The Member-Secretary,
Madras Metropolitan
Development Authority,
Thalamuthu-Natarajan
Building,
No.8, Gandhi Irwin Road,
Egmore, Madras-600 008.

Lr.No. **D.Dis. A1/20885/89** Date: **26.5.'90.**

Sub: MMDA - Planning Permission - **Construction**
of Residential building in Plot No.106 at
S.No. 163 of Nandanbakkam village - Approval
of - Regarding.

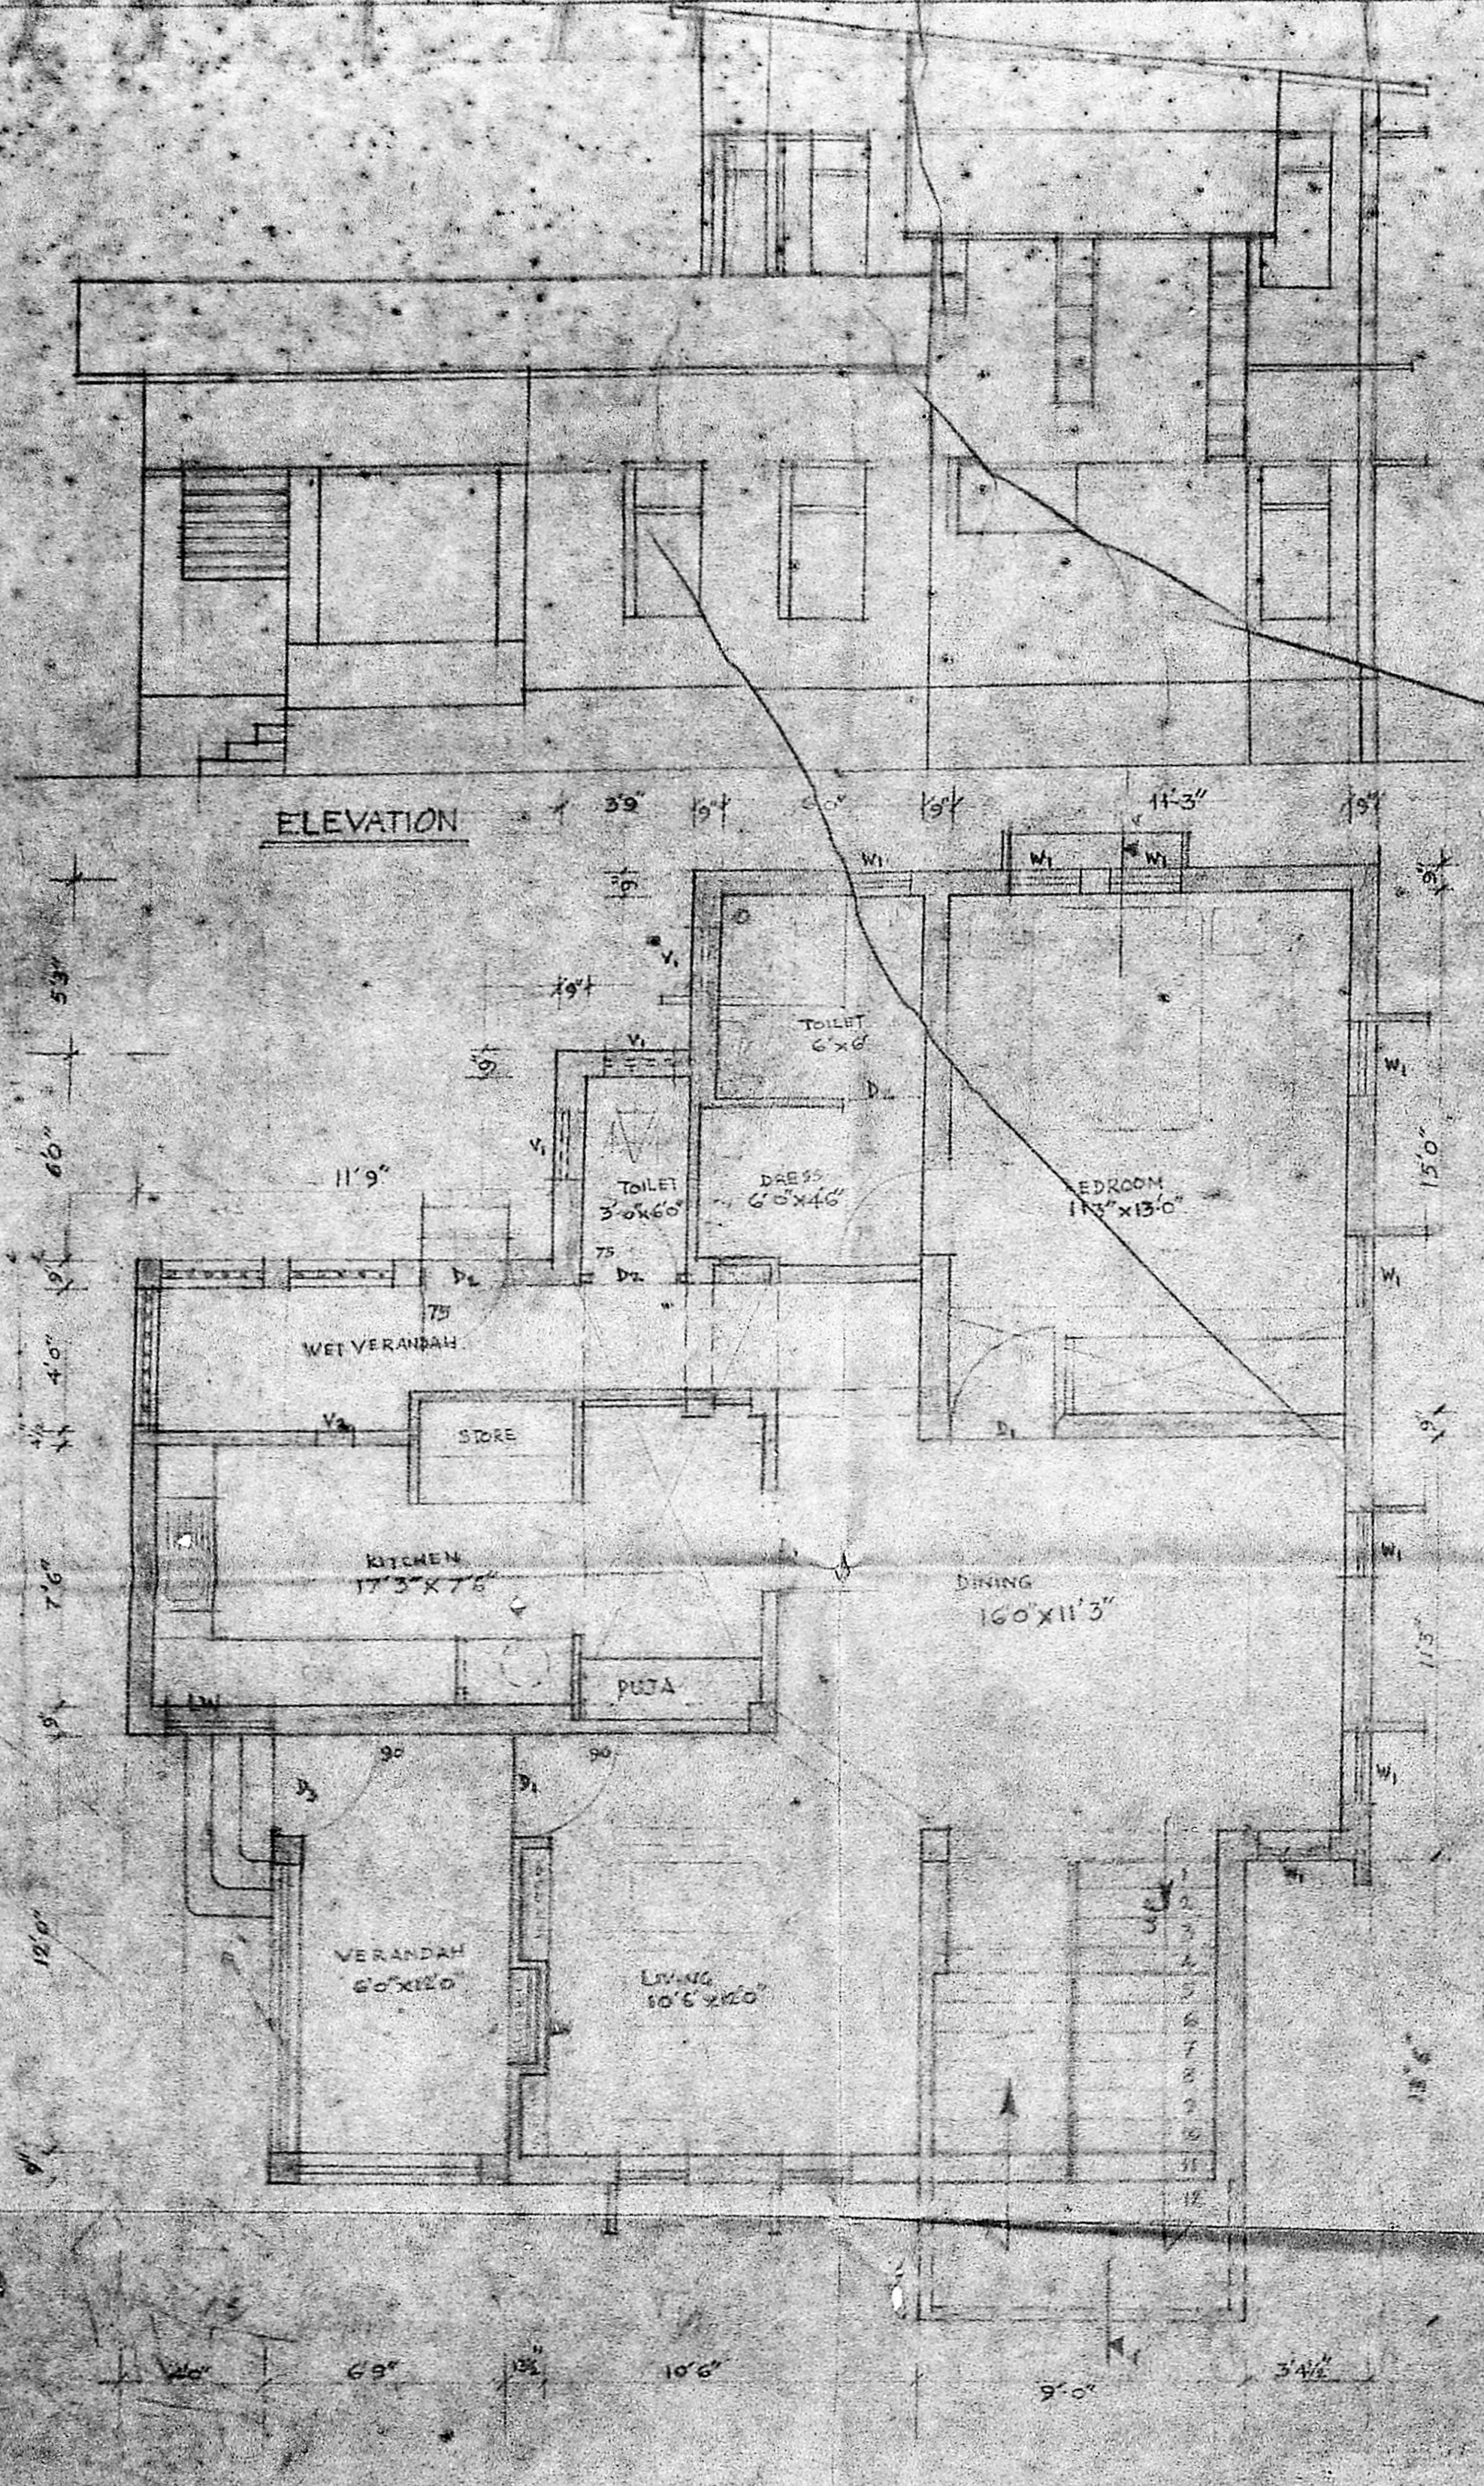
The planning permission proposal received in the
reference cited for the construction of residential building in Plot
No.106 at S.No.163 of Nandanbakkam village was examined and the appli-
cant was requested to submit the revised plans directly
to this office was examined and found that the planning
permission for the same is issuable ~~deleting the Lumber room since~~

~~you have not furnished the Revised plan as requested by this office
letter even no. dt.8.1.'90 and 19.2.'90 and subject to the condition~~
